16 September, 2016

**Re: Australian Border Force Detector Dog Facility (SSD 7692)  
28A McPherson St, Banksmeadow**

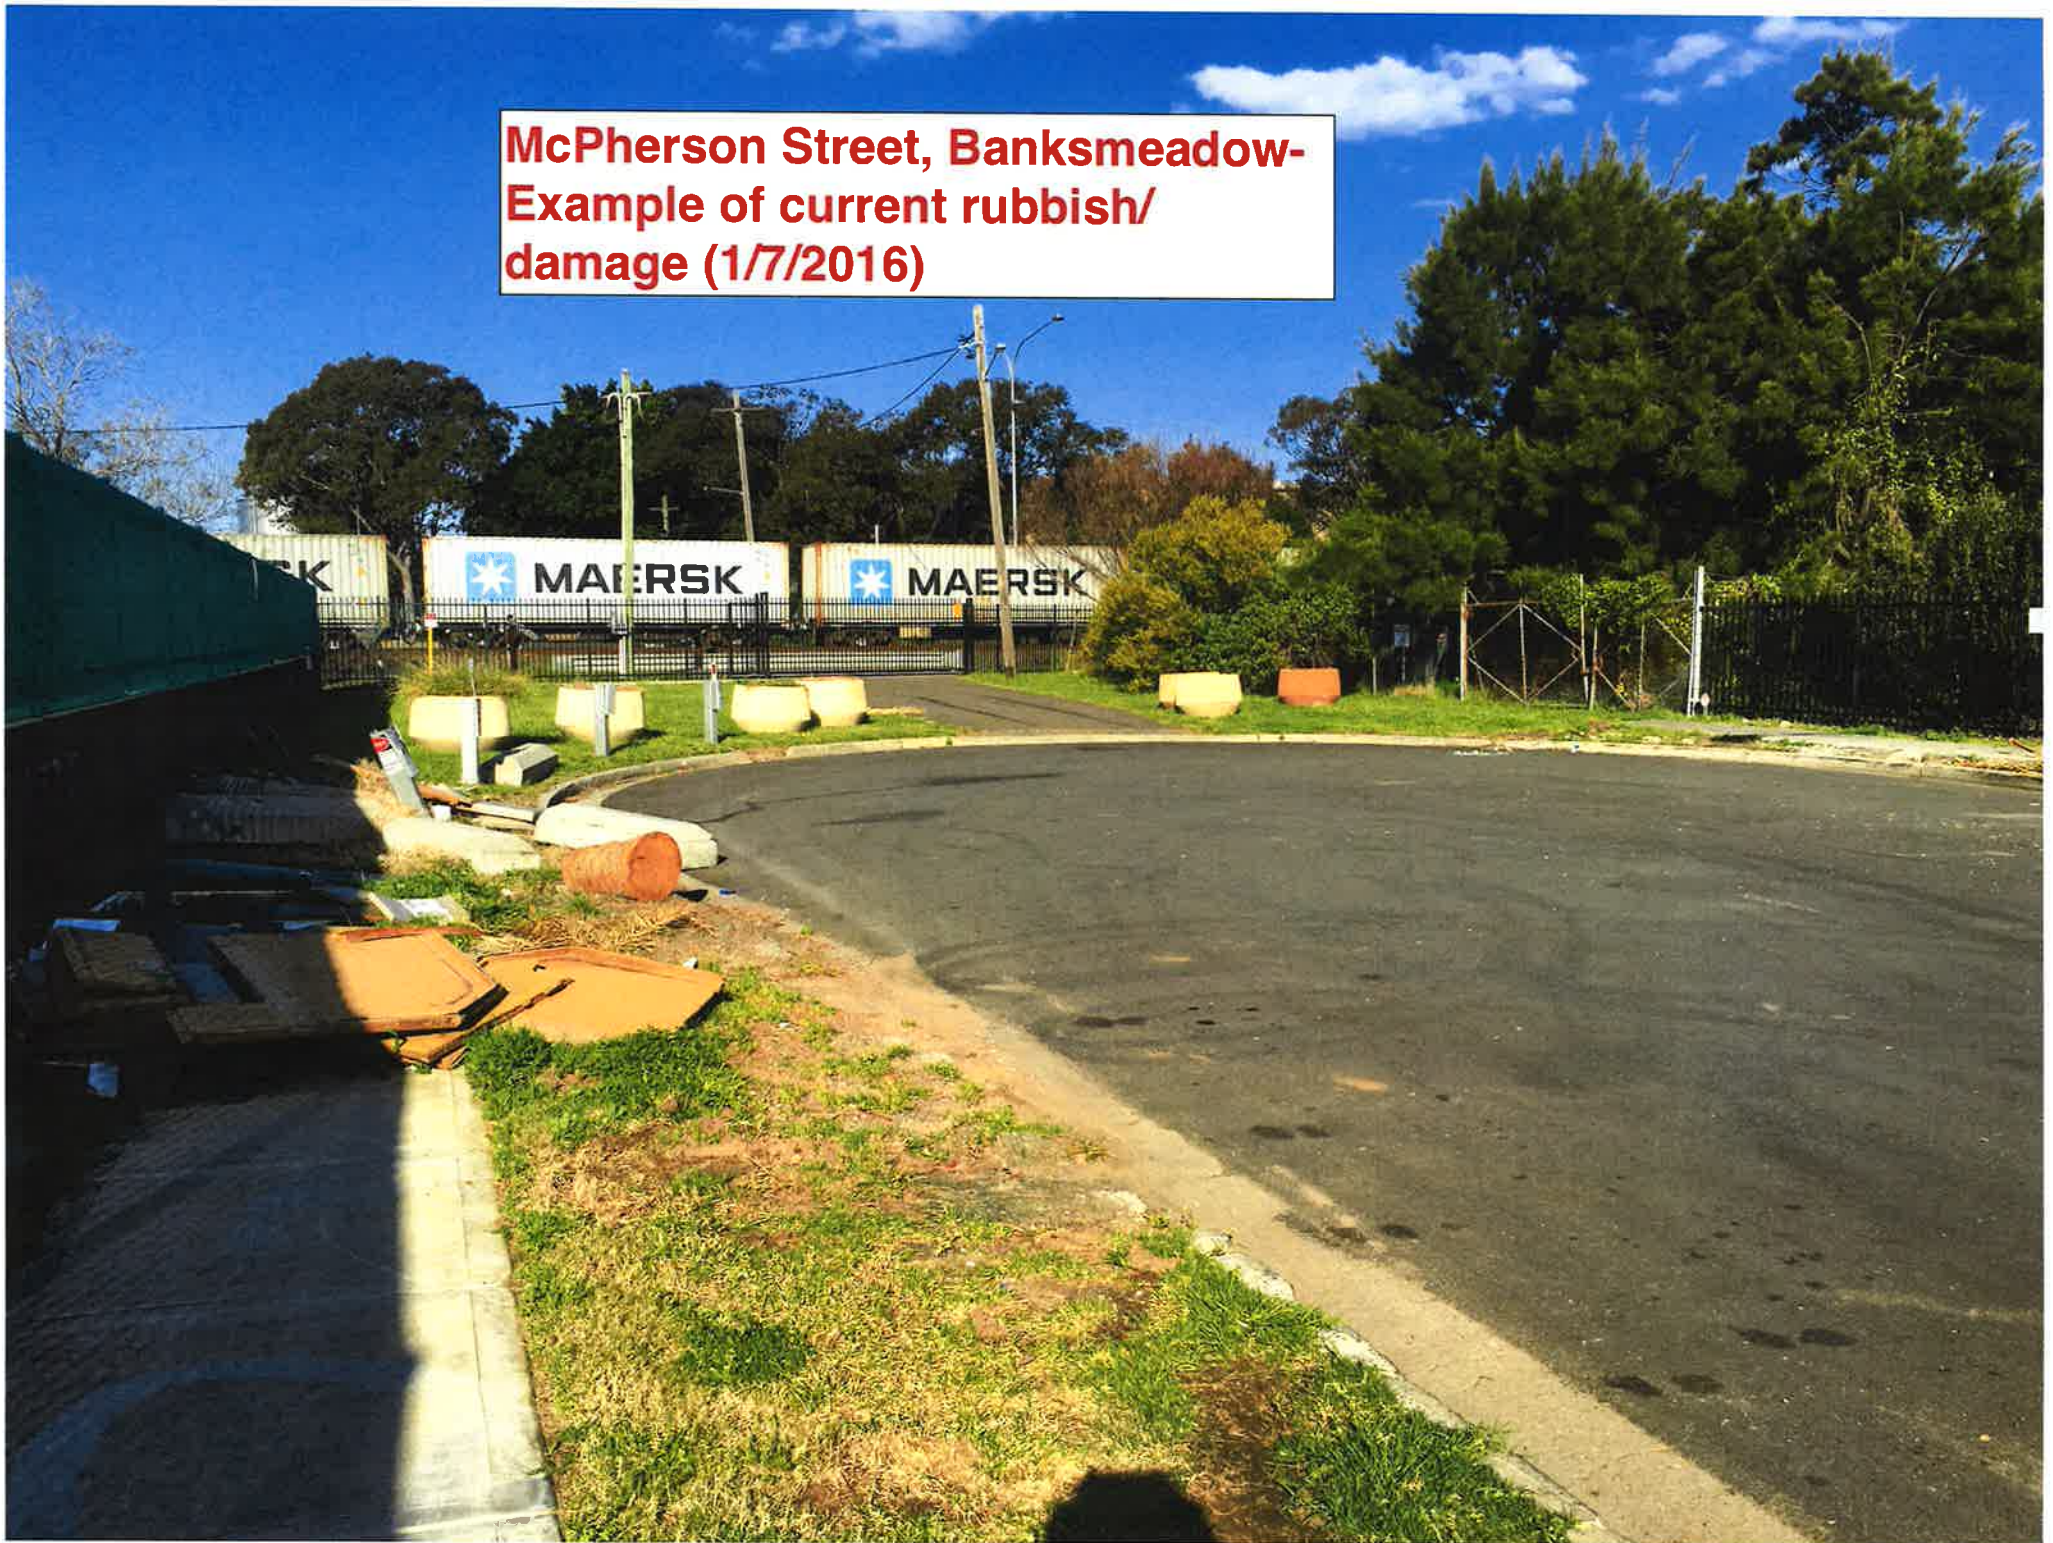
We submit that the cul-de-sac turning bulb at the dead end of McPherson St adjacent to the site frontage should be modified in a manner to allow semi trailers to turn around without doing a three (or more) point turn. Semi trailers do considerable damage in McPherson Street to public and private property while trying to turn around (Refer to photos in attachment 2). We have discussed with Bayside Council's Stephanie Lum and wish to submit a practical low cost solution with details in attachment 1.
